SSD-73761707 - Notification of exhibition of a State Significant Development Application for Honeman Close Warehouse facility

Blacktown City Council's submission to SSD-79500208

TYPICAL ESTATE AND CRASH LAB ROAD

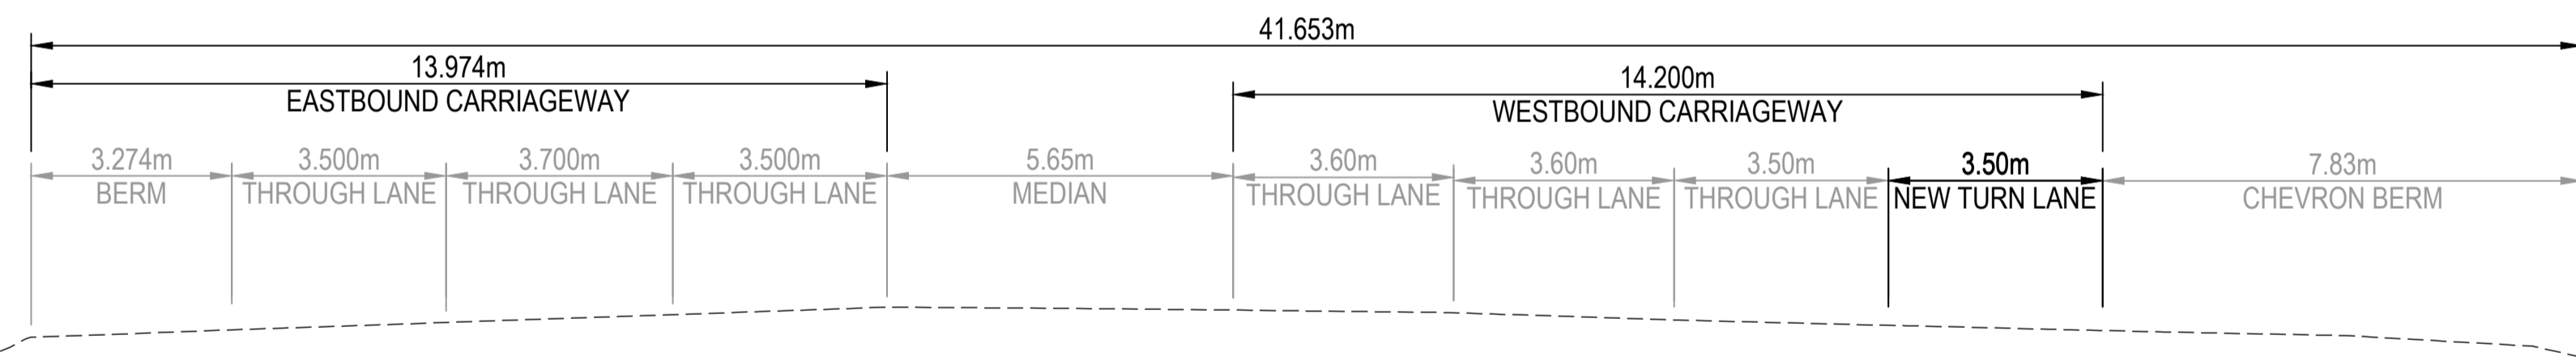
- a. We require the following information to be provided as per Engineering Guide for Development – 2005:
 - i. Pavement Report/Design
 - ii. Long Sections and Cross Section of slip lane (GWH & Estate Road) approved by TfNSW
 - iii. Long Sections and Cross Section of Estate Road with Industrial Cul-de-sac
 - iv. Drains Model for Drainage Design for the roads
 - v. Traffic Management Plan.
